18 November 2009

TBA08-09394N1
LOT 132 DP 1053492 SEC NO LOOKOUT RD RANKIN PARK
(HMRI Buildings)

The Mine Subsidence Board has received correspondence from Mine Subsidence Engineering Consultants (MSEC) requesting that the Board approve a revised design concept for the above project. Documentation to support the application was listed and attached.

Conceptual Subsidence Profile – Coffey's original sketch in black (overlain by Arup notes in red)

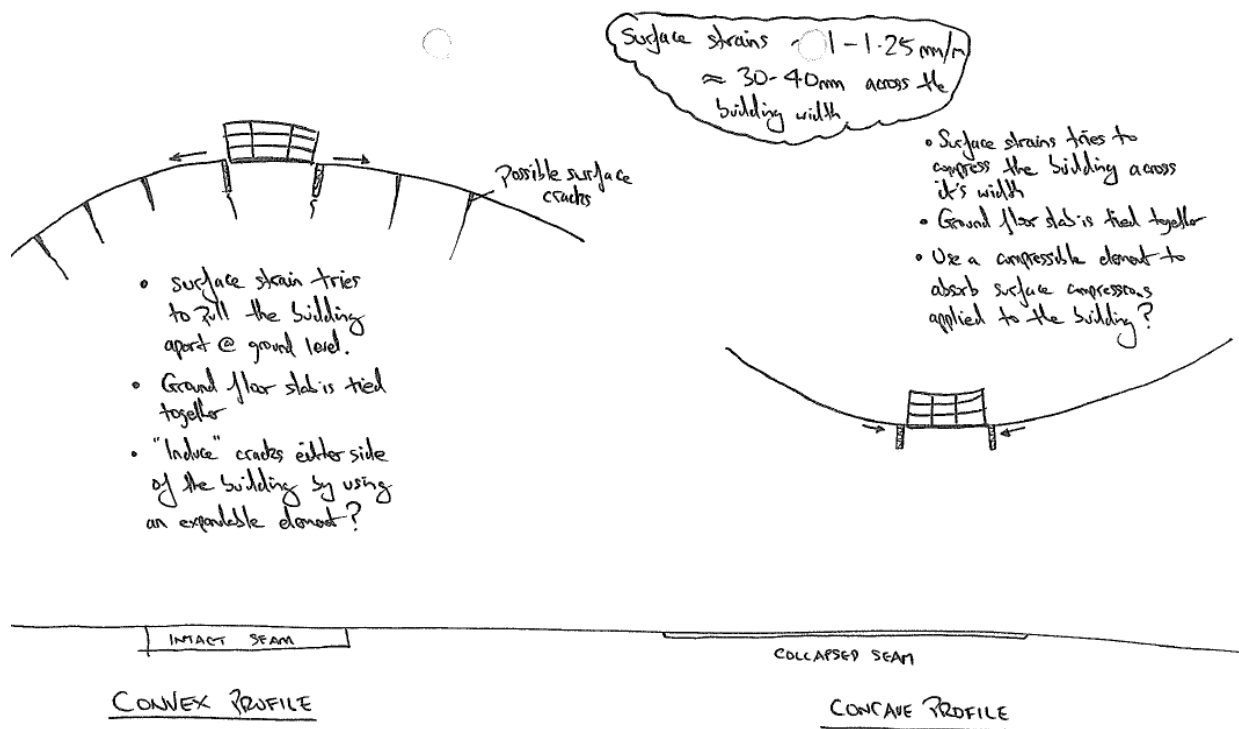
MSEC also advises that a 'subsidence depression could occur in a different location than that indicated and a sensitivity analysis will need to be carried out in this regard.' Clarification is sought as to whether this has been completed and considered for the building design.

**Jacking Access – via manholes to external columns & corridors internally**

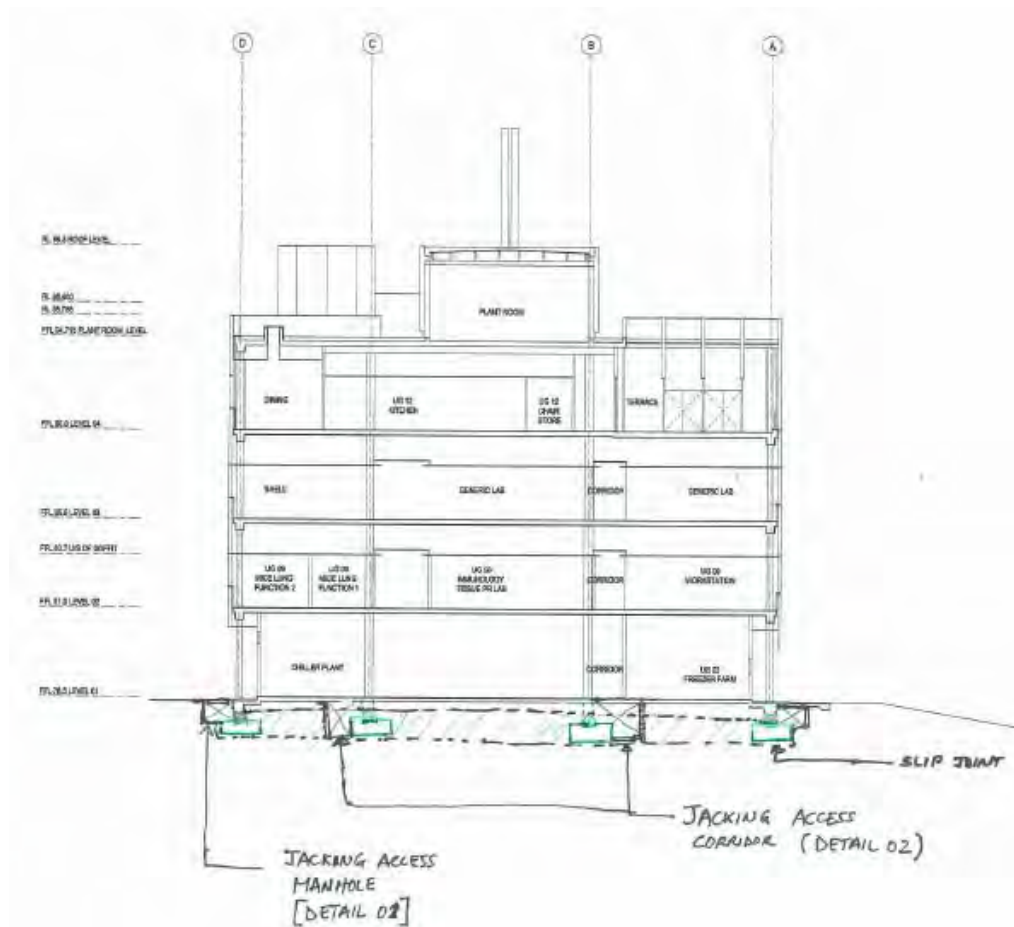
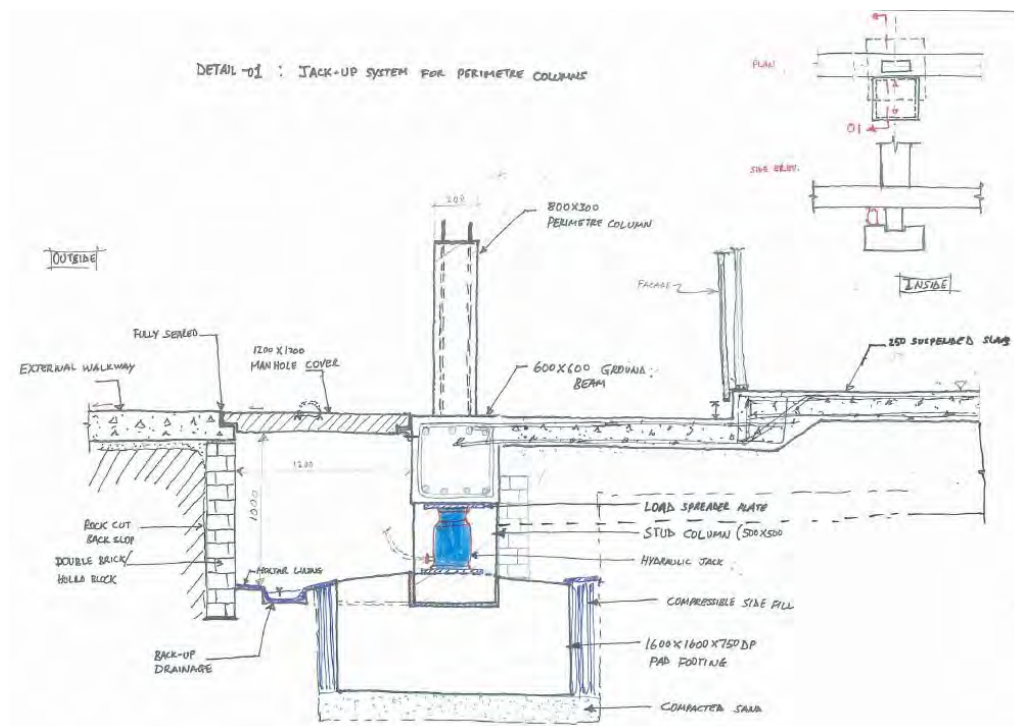
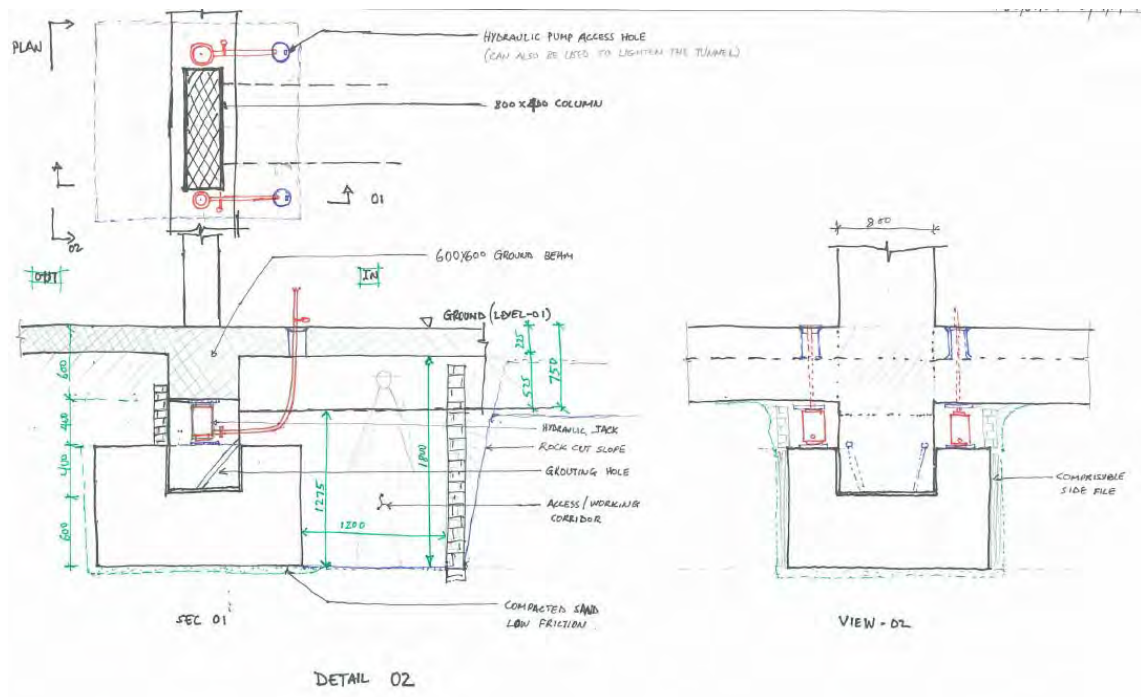
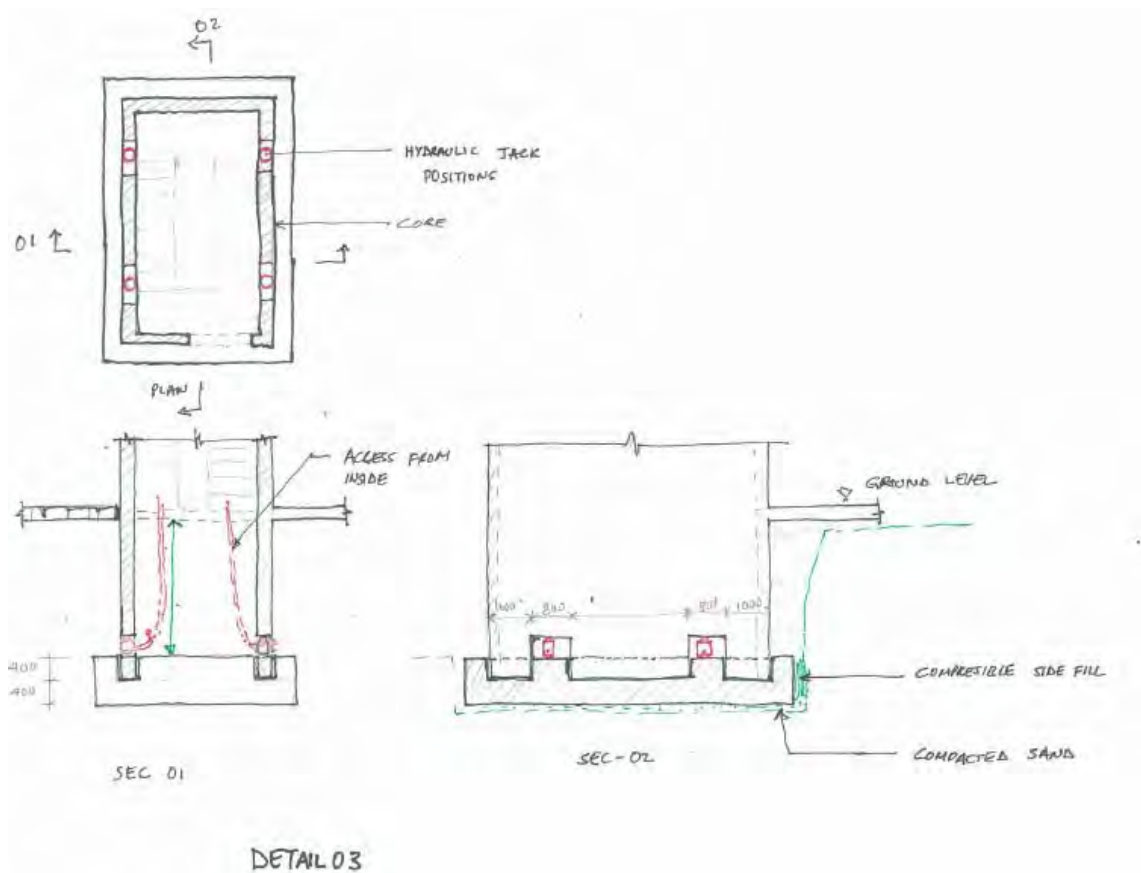
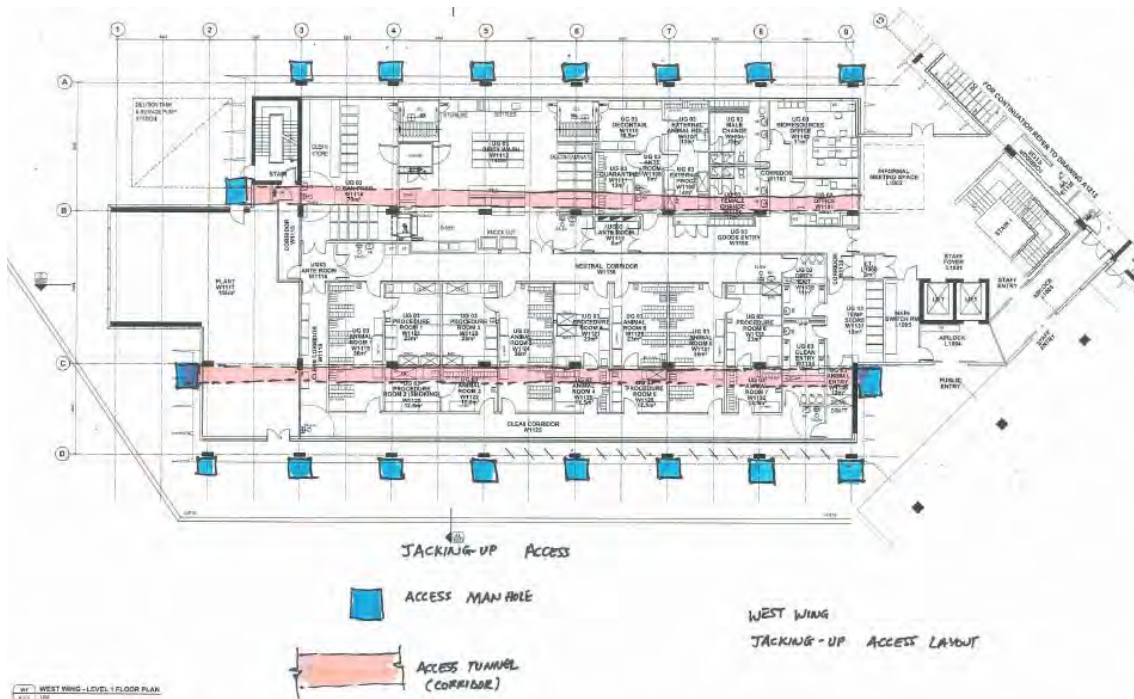
has not changed from this time, other than the proposal to eliminate the jacking component.

The Board has advised it does not relevel structures where tilts are less than 7mm/m. We understand the design principle initial submitted for approval was developed by the applicant's engineers to address the function of the building. As predicted tilts are well less than 7mm/m this was not a matter for the Mine Subsidence Board
